Recommendation Report for Planning Permission for Works or Extension to a Dwelling

REF NO: FP/137/19/HH

LOCATION: 2 Second Avenue
Felpham
PO22 7LJ

PROPOSAL: Single storey front garage extension, first floor rear extension and additional ground floor rear extension (resubmission following FP/160/18/HH).

PROPOSED ROOF PLAN

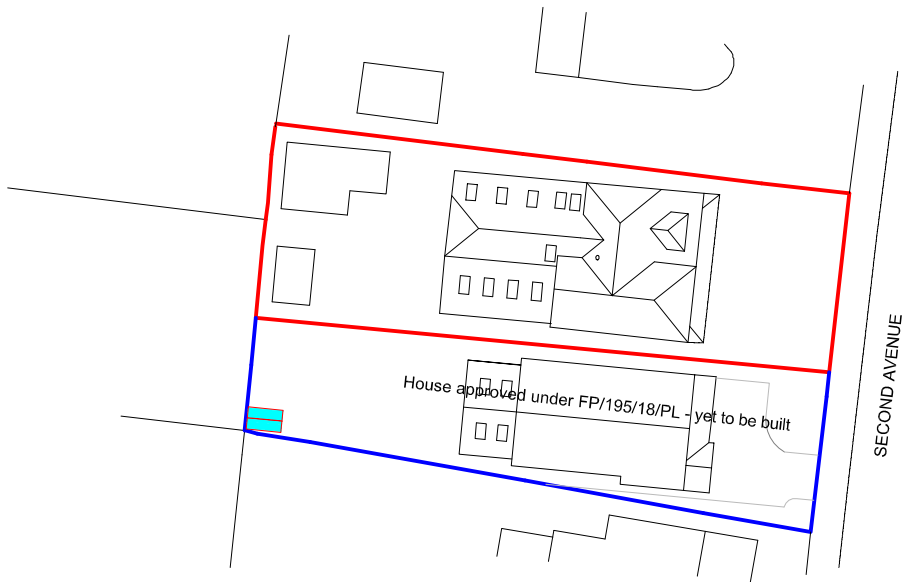
There will also be 4 rooflights however these will not give rise to overlooking as a result of their height above ground floor level.

PROPOSED ELEVATIONS

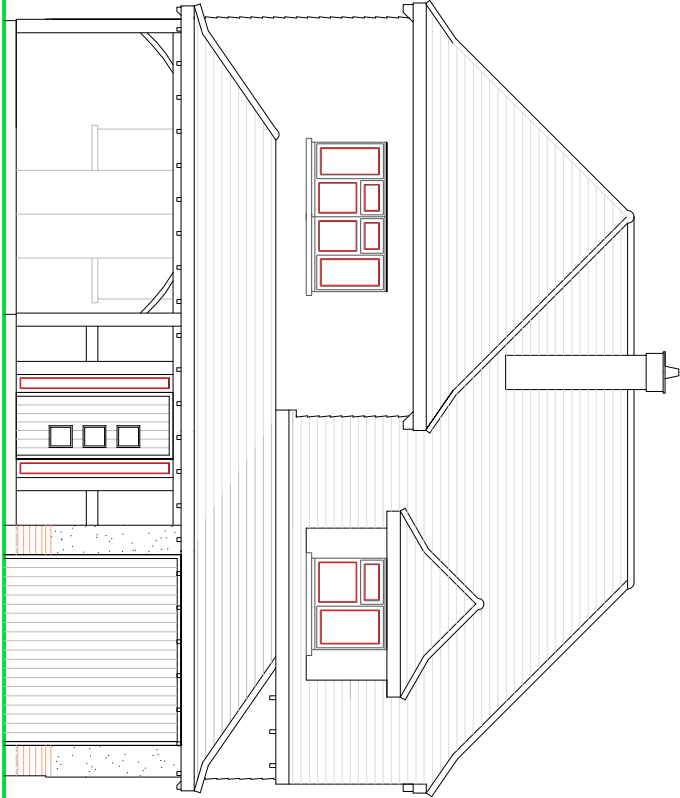
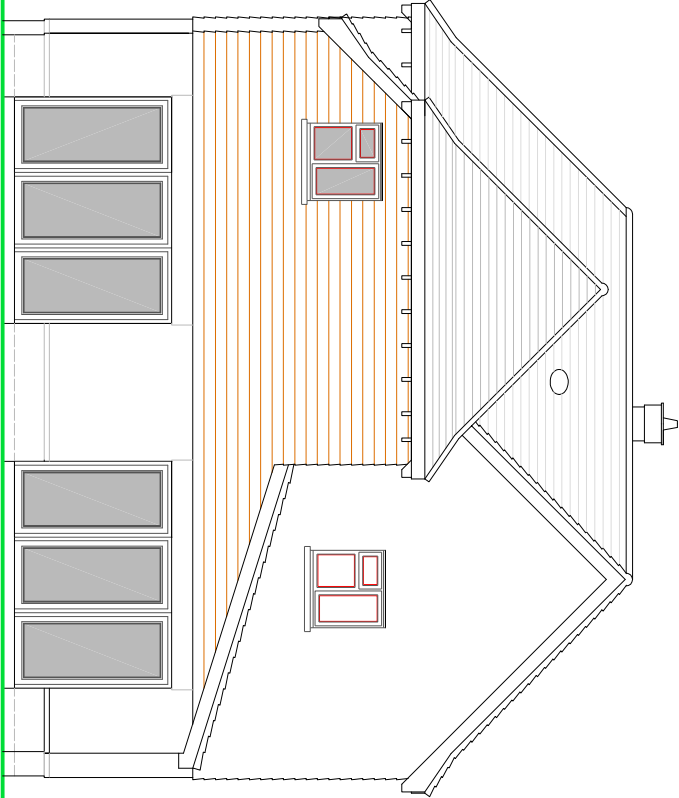
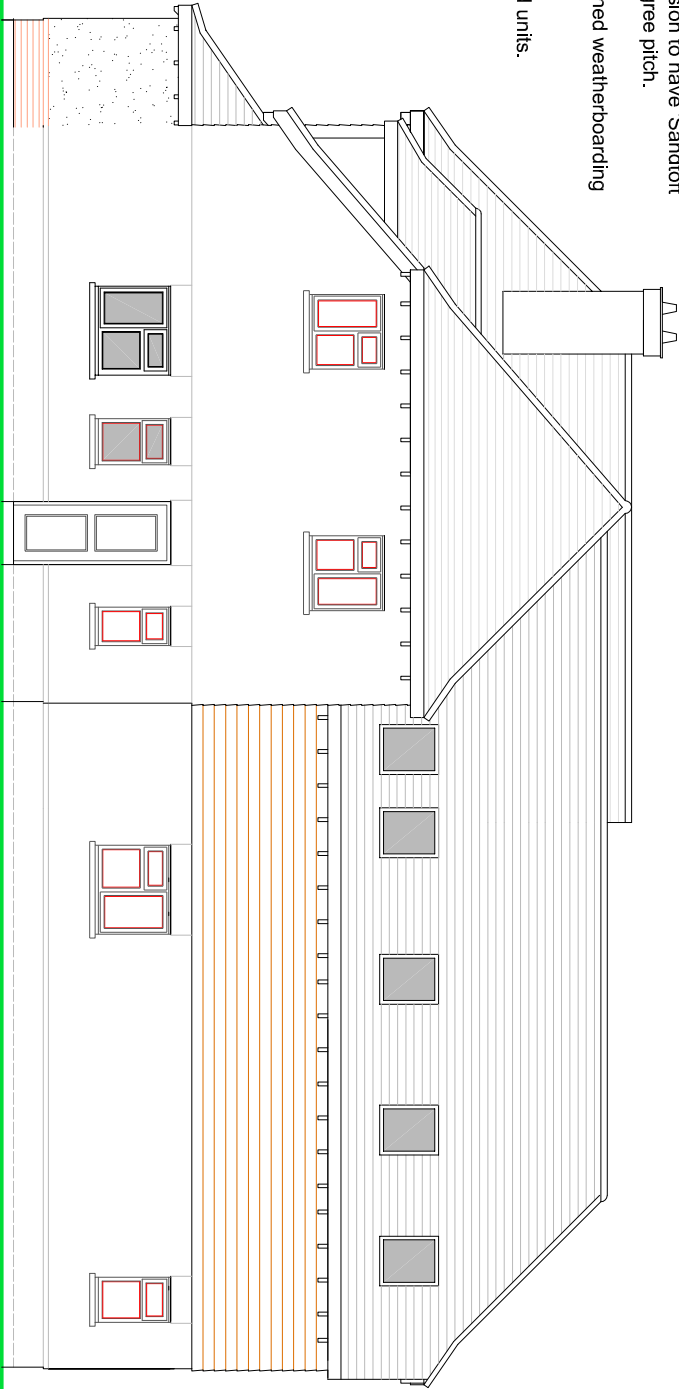
The rear elevation will consist of a two storey extension which will reduce to single storey. The single storey addition will have a width of approximately 4m however this does not extend beyond the side elevation. The extension will have a lean to roof with a maximum height of 3.8m reducing to 2.6m.

Two windows are proposed to the southern elevation however these are smaller than that which already exist at this elevation. They would face towards the neighbouring dwelling (yet to be built) however with fencing in place and the development at single storey, views are not considered to be adverse or increase significantly from that which is already possible. 1.3m is also retained to the southern boundary.

The height of the two storey extension to the rear also increases in height by approximately 0.2m however this is not considered to result in additional adverse impacts.
